TERRA ASSOCIATES, Inc.

August 5, 2022
Project No. T-8264

Subject: Response to City of Mercer Island Comments
Cheshire Short Plat
7615 East Mercer Way
Mercer Island, Washington

**APPENDIX B**  
**RELATIVE SLOPE STABILITY RESULTS**

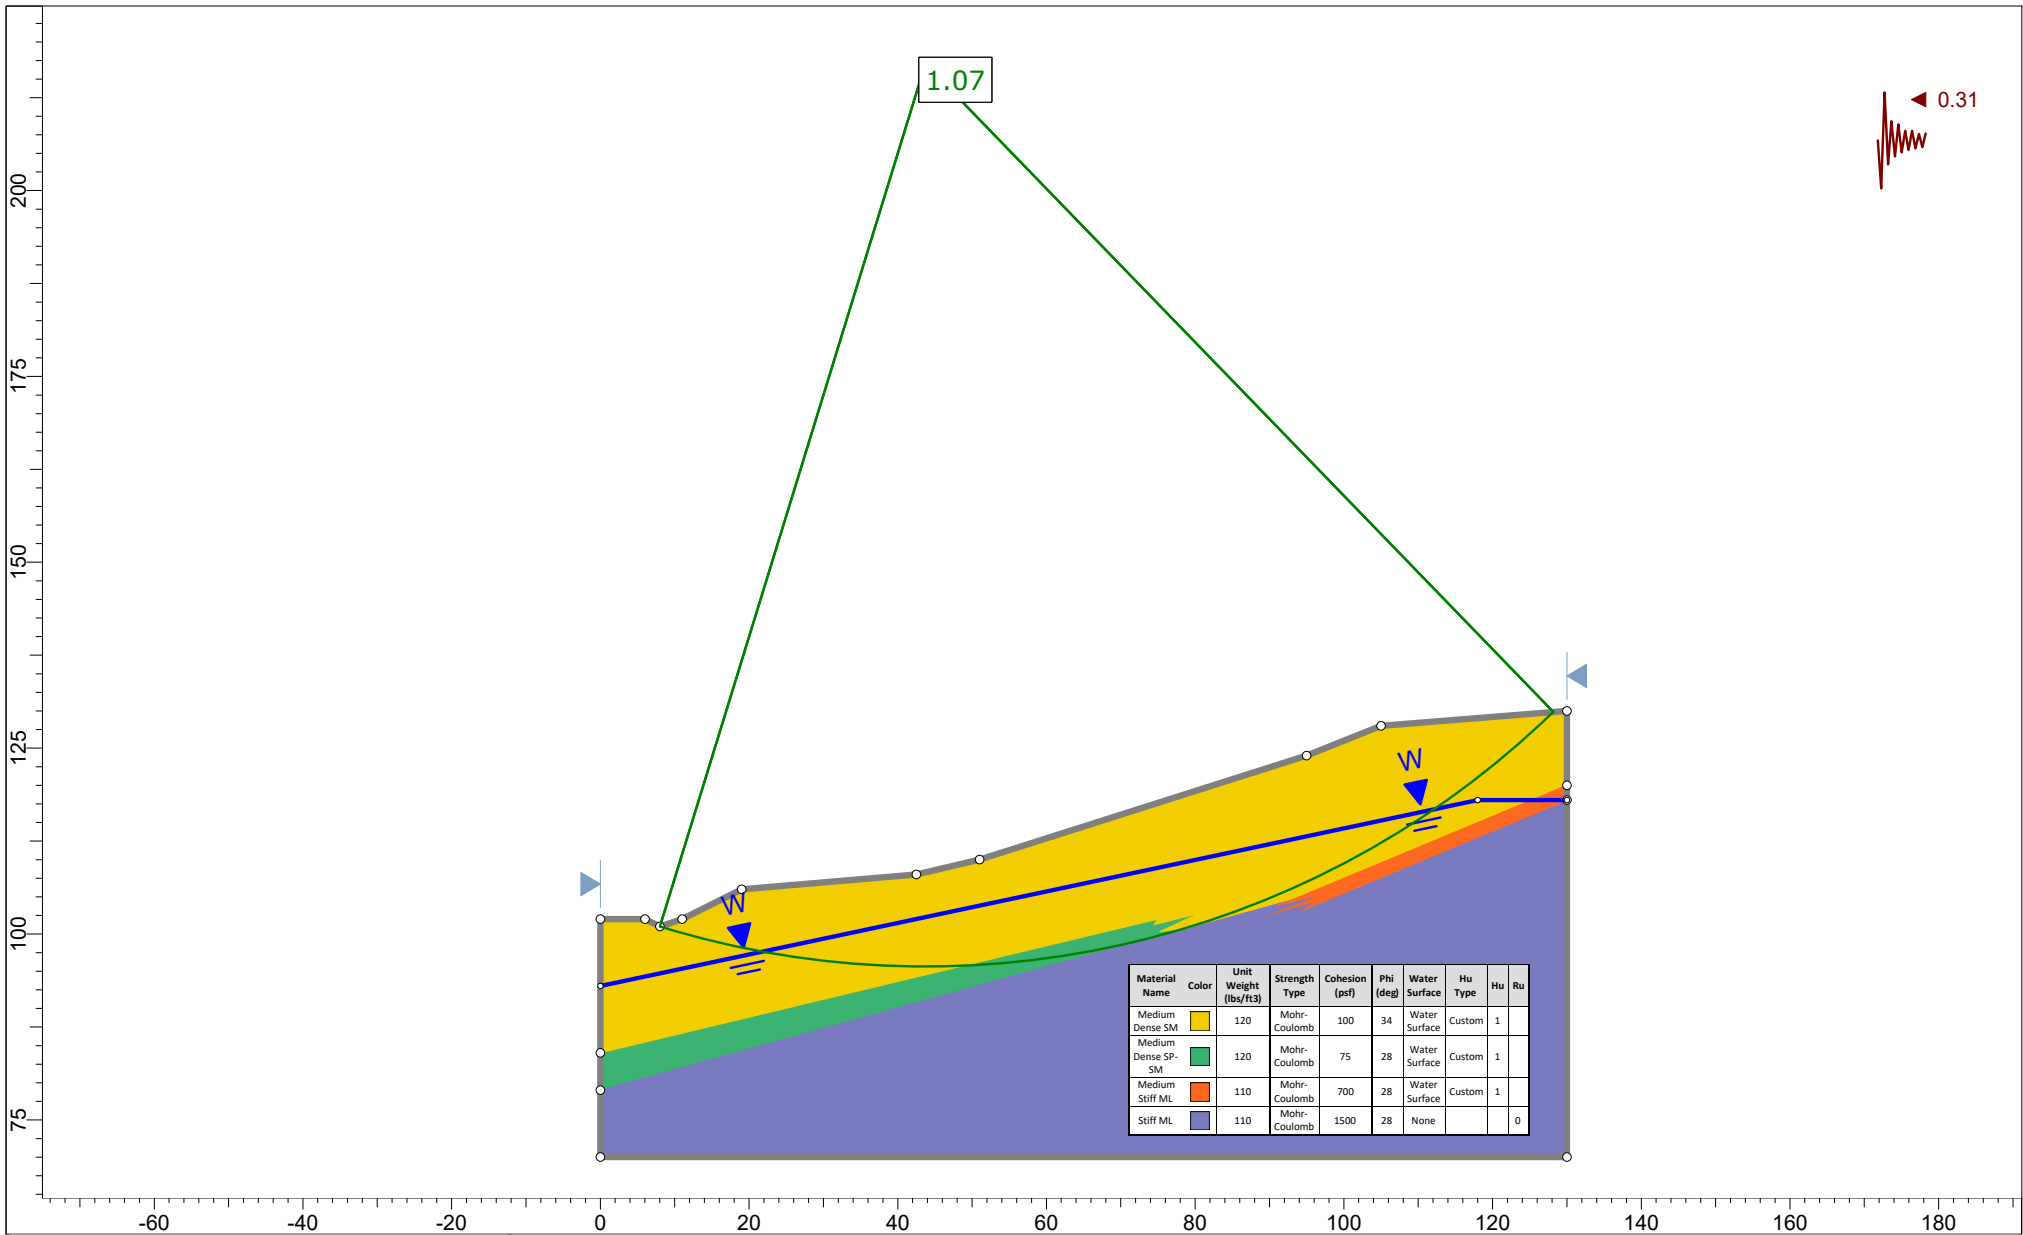
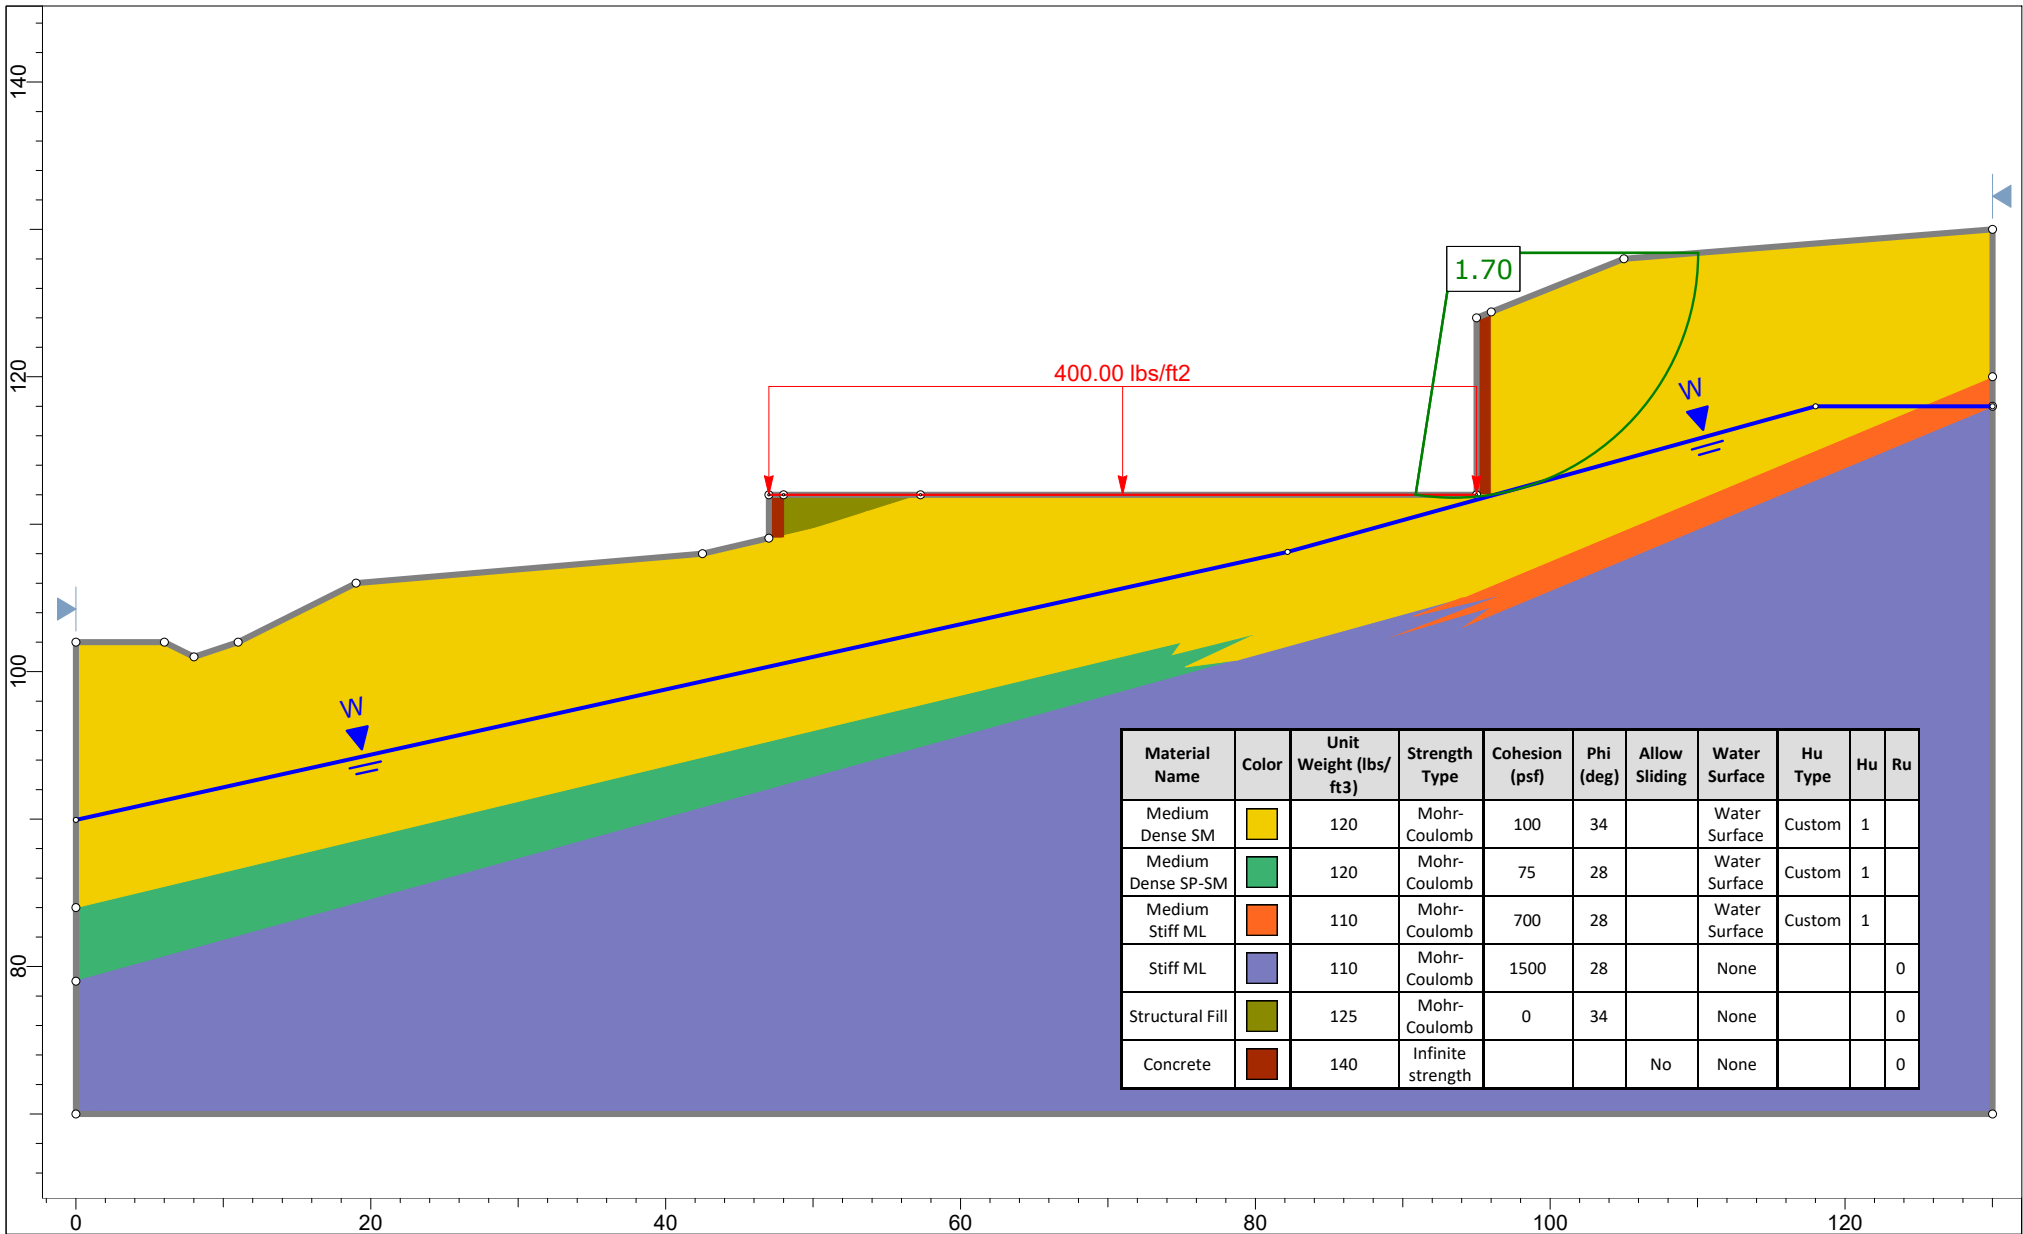
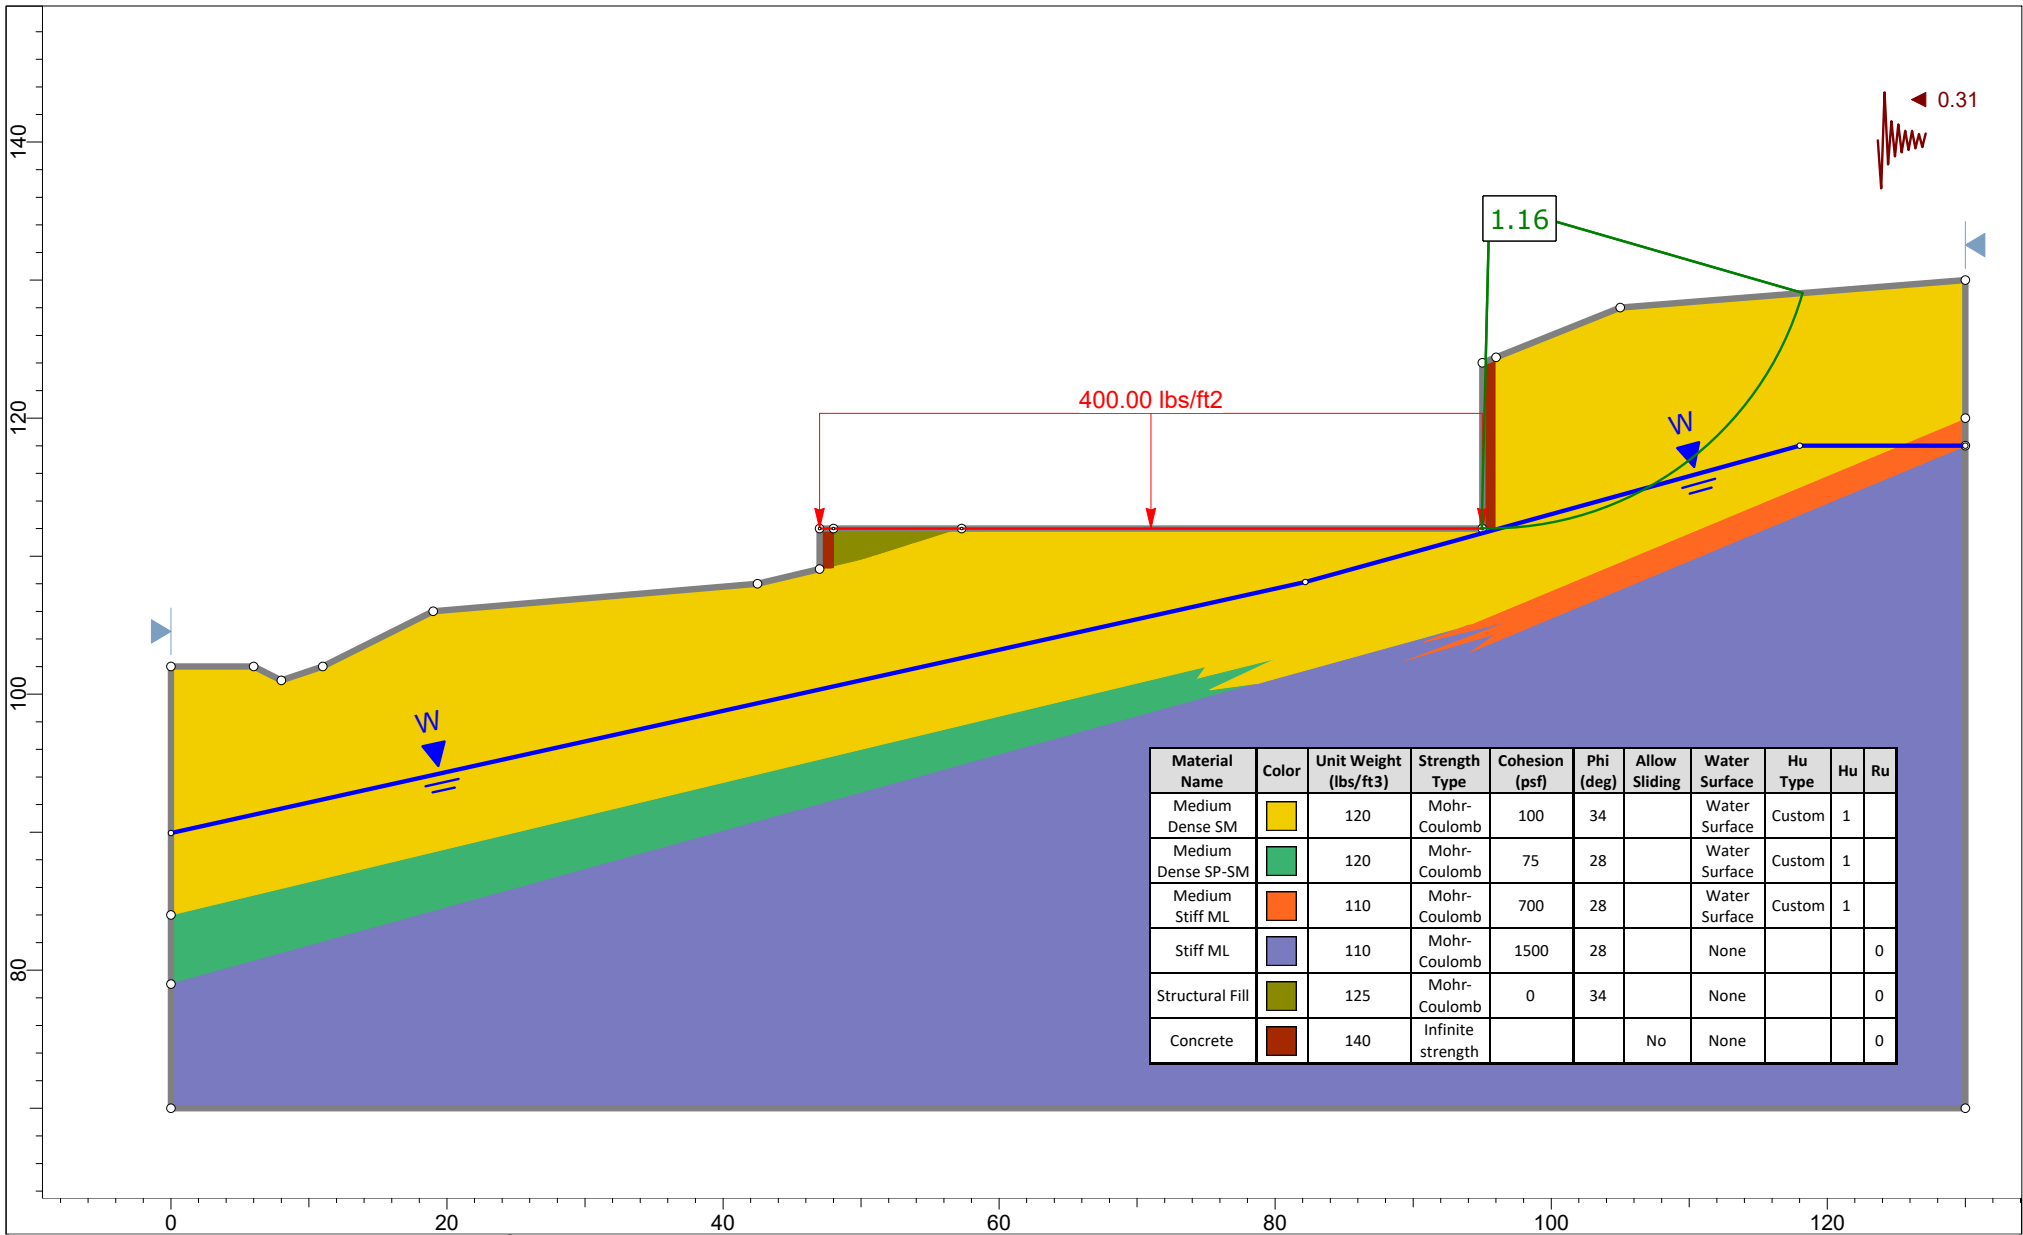
The slope stability analyses for this site is based on one boring. One data point is not sufficient to construct a cross section. Please discuss how the cross section was determined as well as supporting data for the soil strengths used in the analyses. Specifically include discussion of how residual strengths were incorporated for soils characterized as landslide soil.

The slope stability analyses may need to be revised following review of the soil strength information provided and results of liquefaction analyses.

The slope stability has been revised and is based on two test borings completed in June 2022. As noted above there is no evidence of widespread landslide debris or evidence of a landslide plane. A slide plane would be needed to determine where to apply residual soil strengths. Therefore, using residual strengths for the stability analysis is overly conservative and is not based on onsite subsurface data.

# LIQUEFACTION ANALYSIS

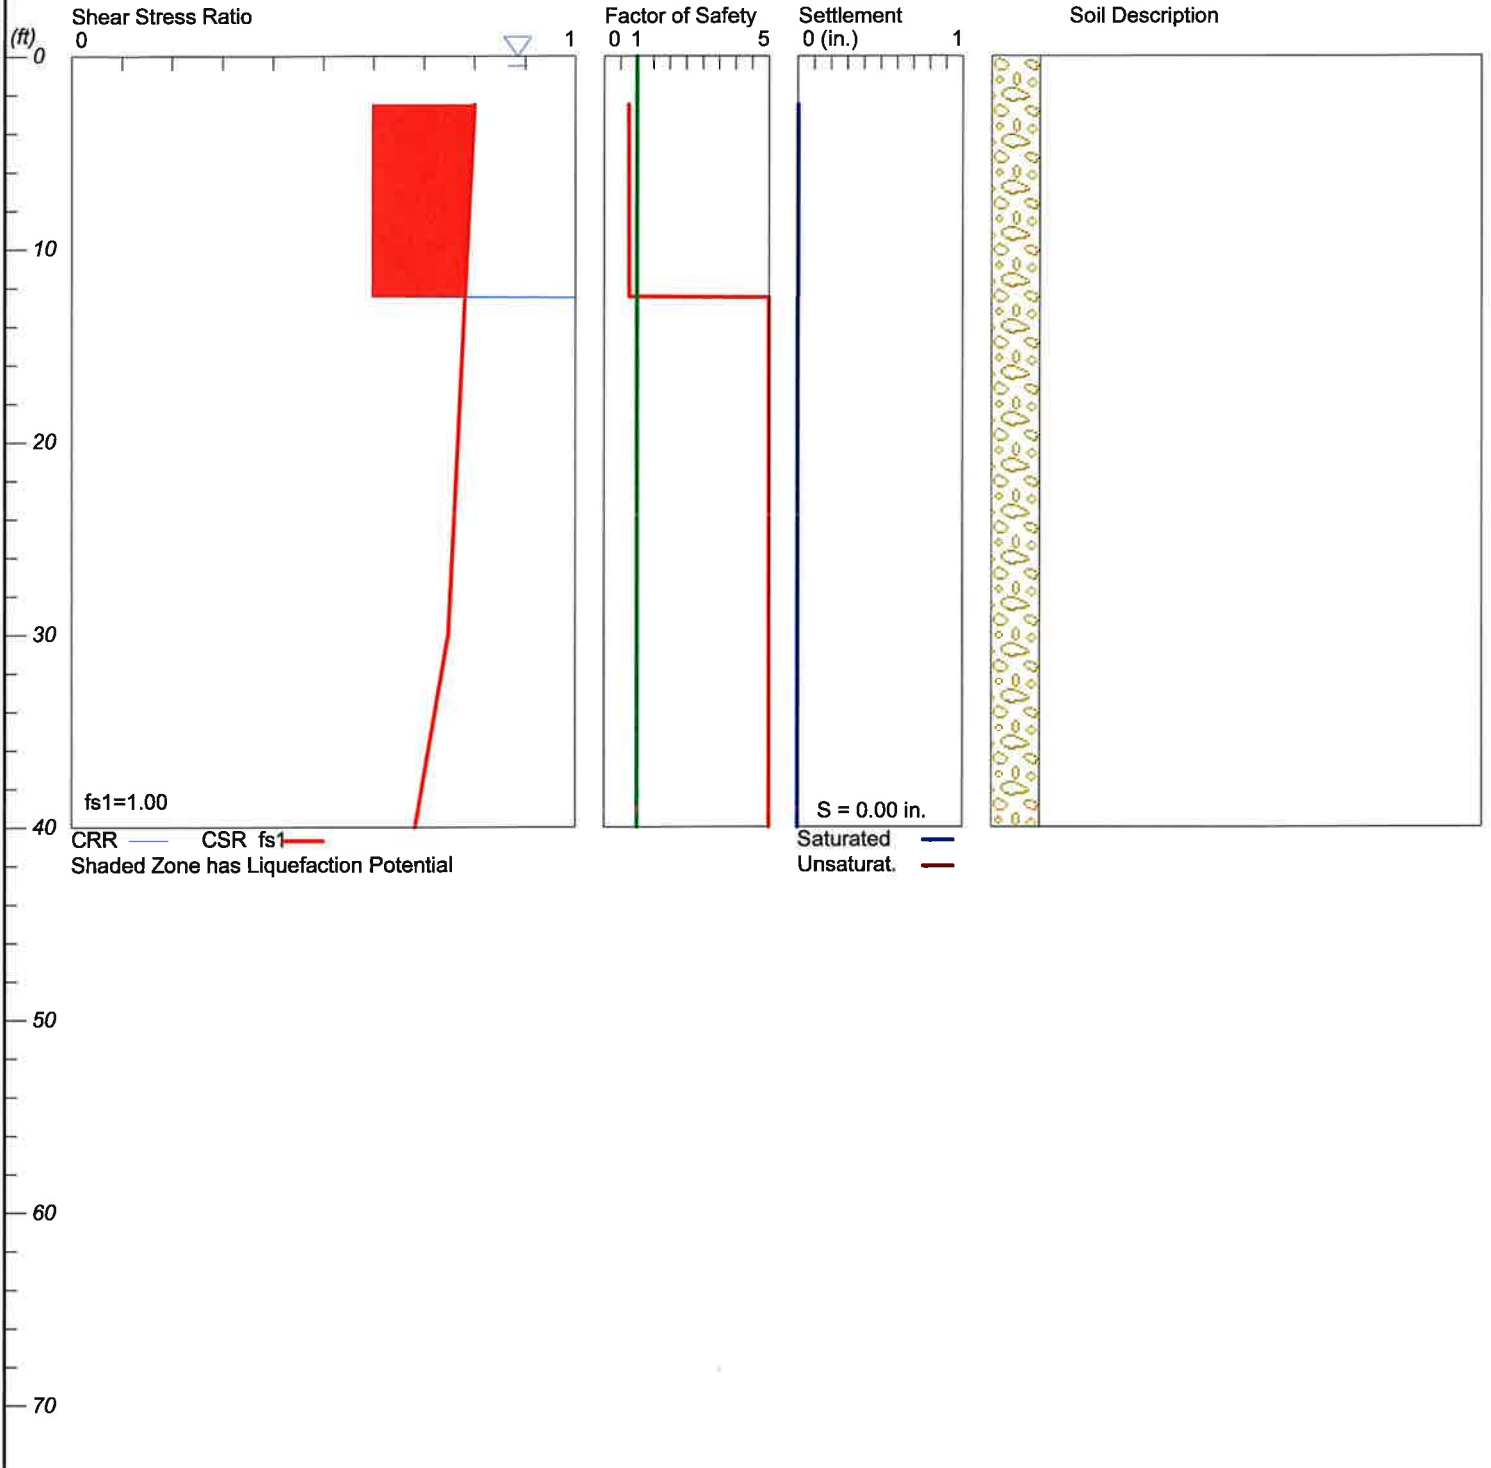
With the presence of groundwater and loose sand onsite provide calculations for review to verify there is sufficient Factor of Safety against liquefaction.

We completed a liquefaction analysis using the computer program LiquefyPro published by CivilTech Corporation. The analysis was completed using a ground acceleration value of 0.62g, which is the ground acceleration for the maximum considered earthquake (MCE) for an earthquake with a 2,500 return-period. The value was determined using the U.S. Geological Survey (USGS) web-based Unified Hazard Tool.

The results of our analysis indicate soil liquefaction could occur during the design earthquake event, resulting in total settlements approaching approximately 2.8 inches, with one-half of that settlement likely being differential in nature. Results of the analysis are attached to this letter.

In our opinion, this amount of settlement would not structurally impact the building but would result in damage of a cosmetic nature. If the owner is not willing to accept the risk of cosmetic building damage requiring repair in the event of seismic-induced settlements occur, foundations would need to be supported on ground improved with stone columns or rammed aggregate piers. Based on our experience with similar sites and structures, structural design elements are also available to mitigate potential damage caused by the seismic-related soil settlements.
